**Our Case Number:** ACP-323851-25

**Re:** Proposed construction of the Celbridge Hazelhatch Mobility Corridor  
Celbridge Town, County Kildare

**Iascach Iníre Éireann  
Inland Fisheries Ireland**

**Planning Reference: The construction of a new road, pedestrian footpaths, and cycle lanes as part of an active travel corridor known as the Celbridge Hazelhatch Mobility Corridor, located in Celbridge Town, County Kildare. The proposed corridor spans approximately 2km, commencing at a new junction with Clane Road (R403) and extending southeast through predominantly greenfield lands. The corridor connects with the R405 Hazelhatch Road and terminates at the Loughlinstown Road Roundabout near Hazelhatch and Celbridge Train Station. A new bridge crossing over the River Liffey is proposed approximately 200m south of the Clane Road junction**

Title
RIVER LIFFEY CROSSING
General Arrangement
(Sheet 2 of 3)

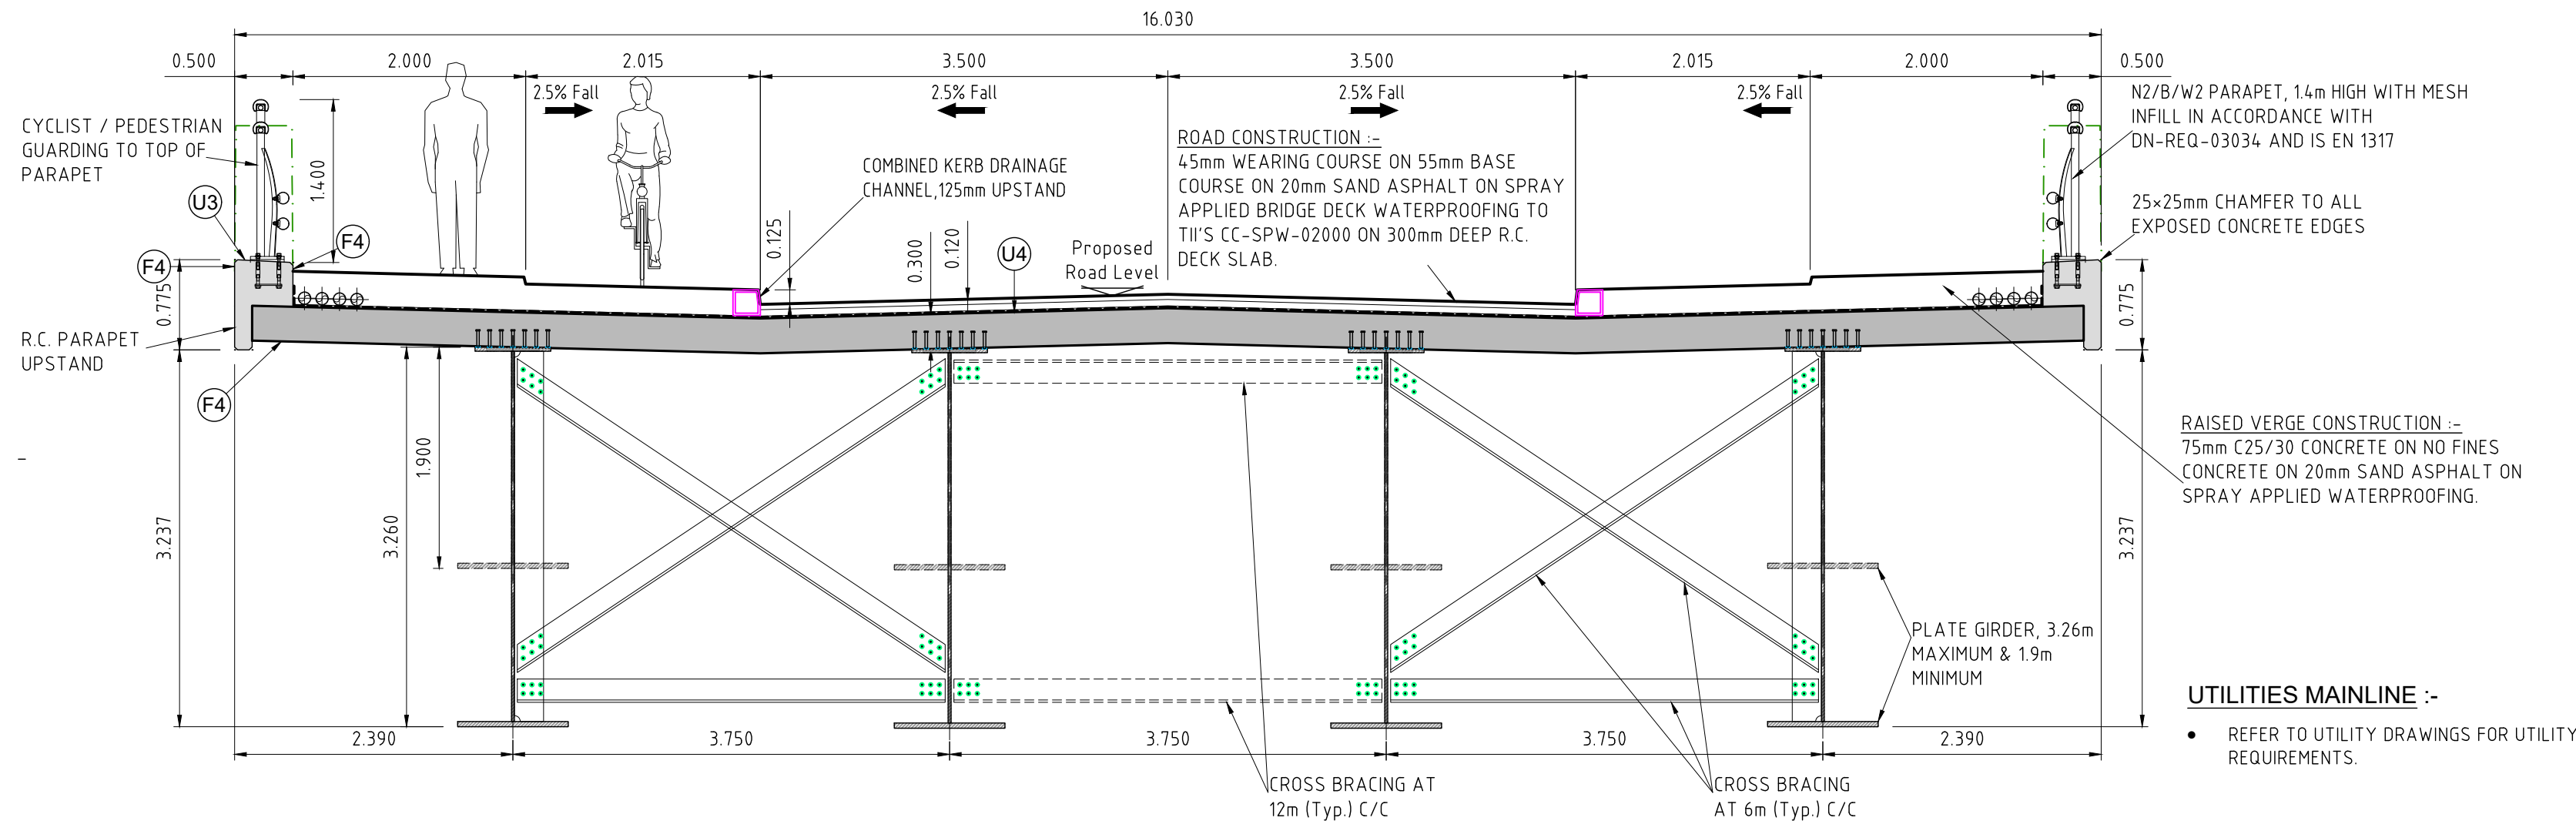
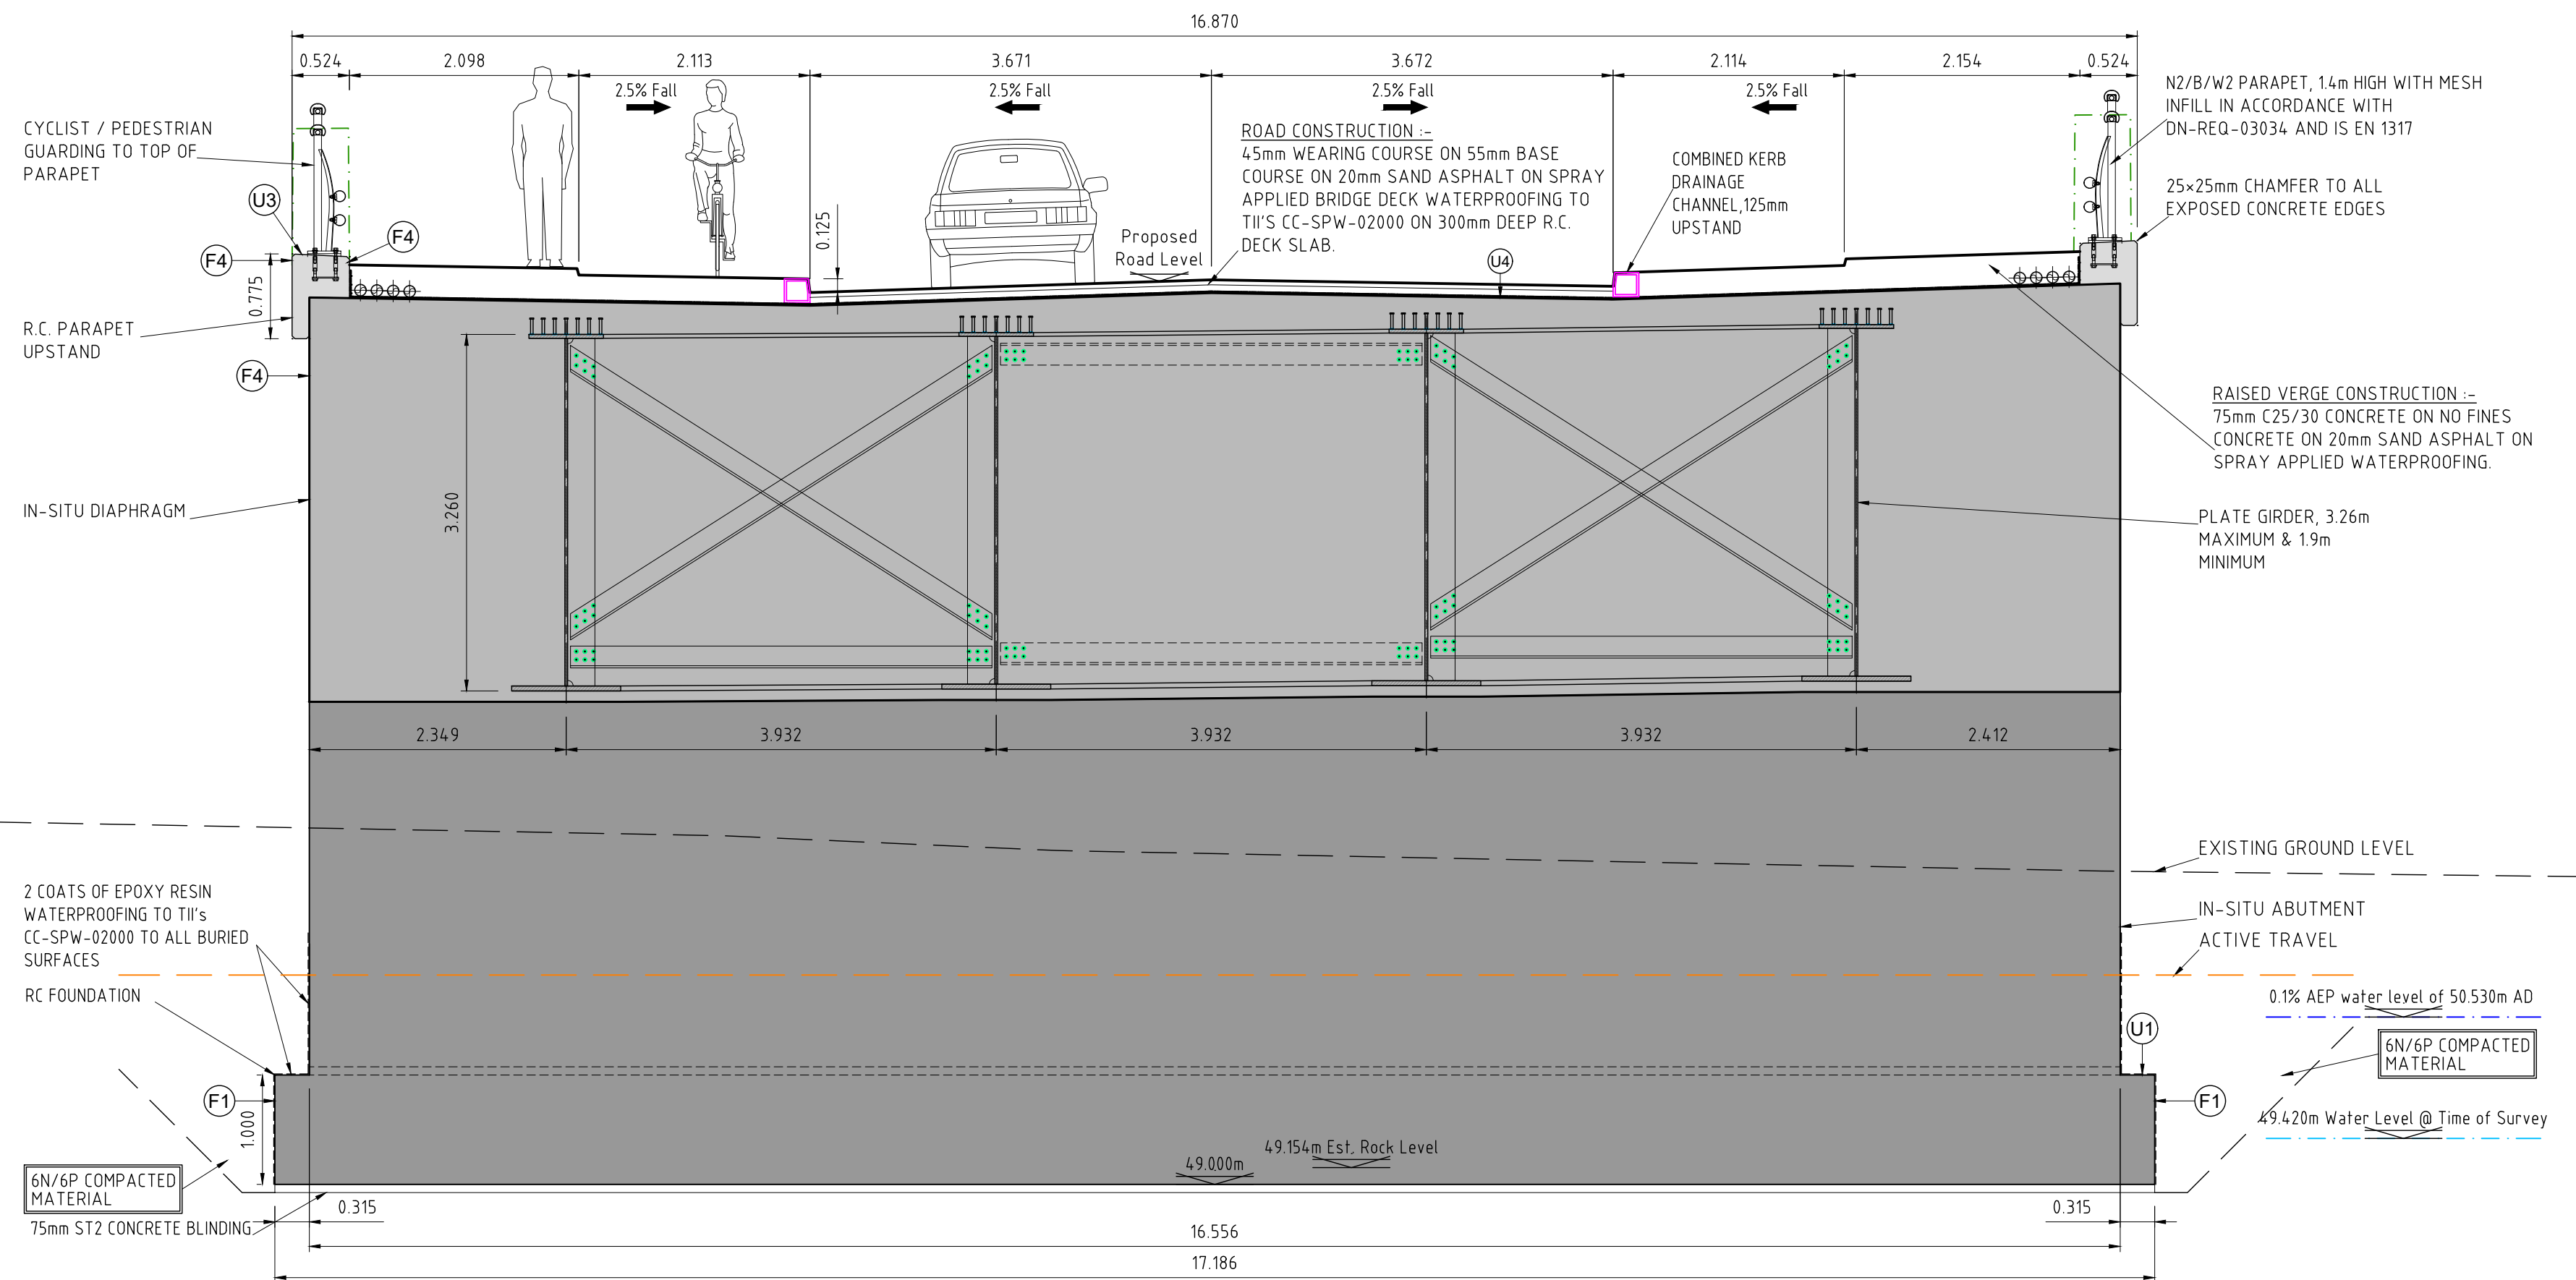
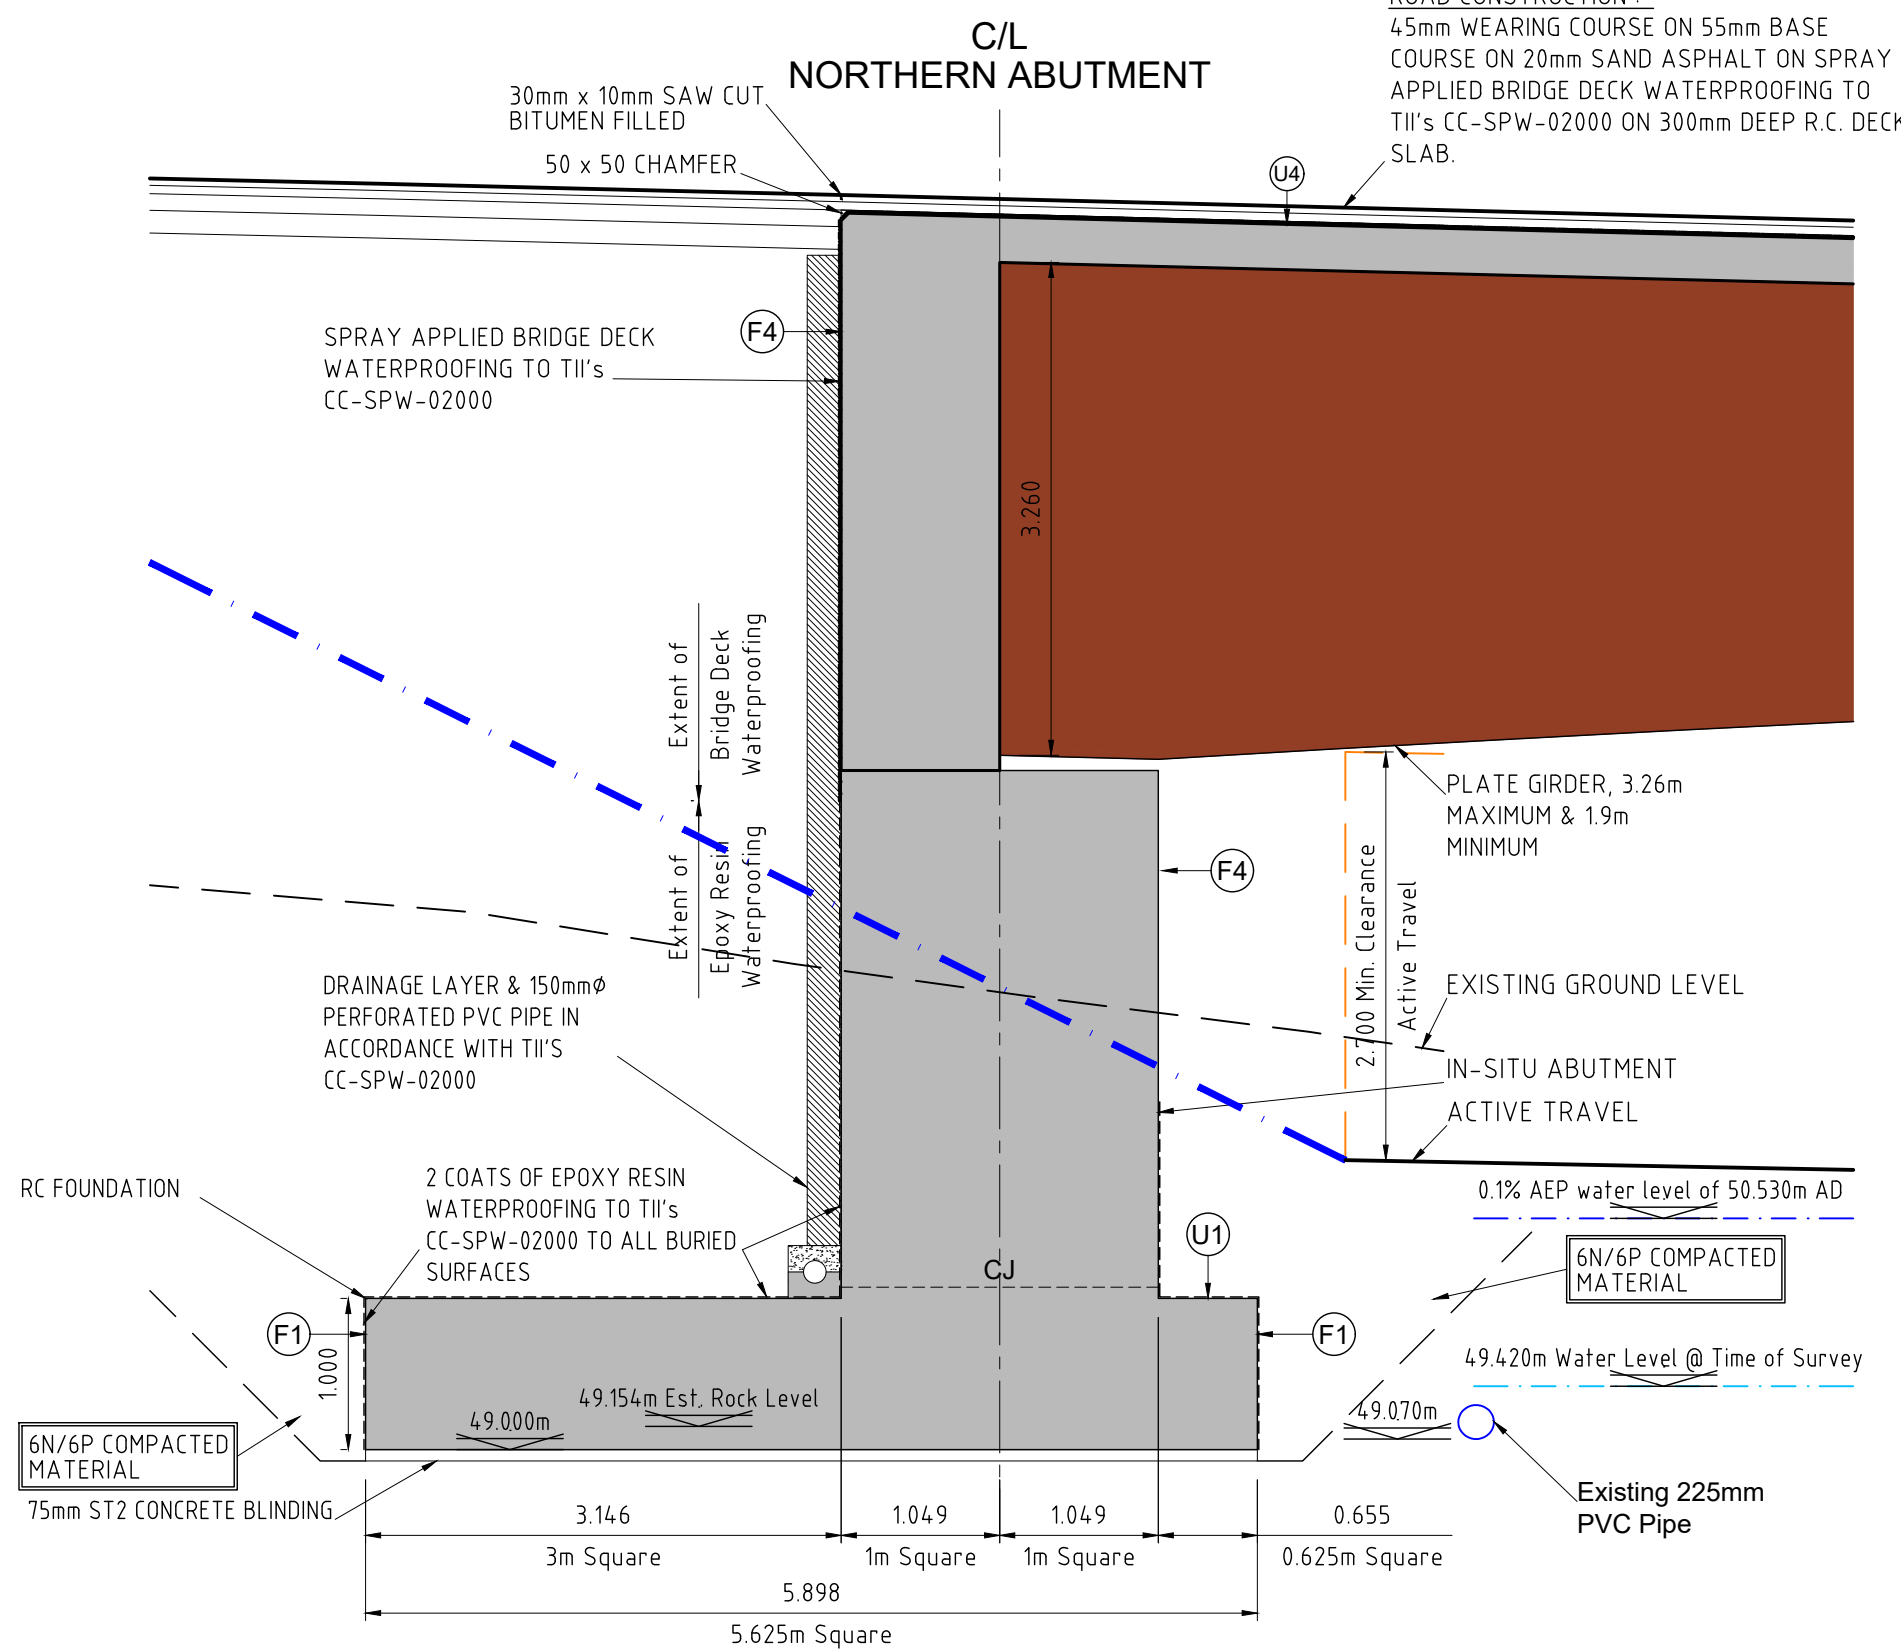
- Detail design and subsequent method statements for the new bridge over the Liffey must be submitted to IFI for approval. Instream works can only take place from 1st July to 30th September. Bridge foundations should be positioned at least 4.0m back from the wetted river channel as not to impact the riparian habitat. (Consultation between the project team and IFI will be essential in order that a fisheries-sustainable solution is arrived at and incorporated in the final works programme).
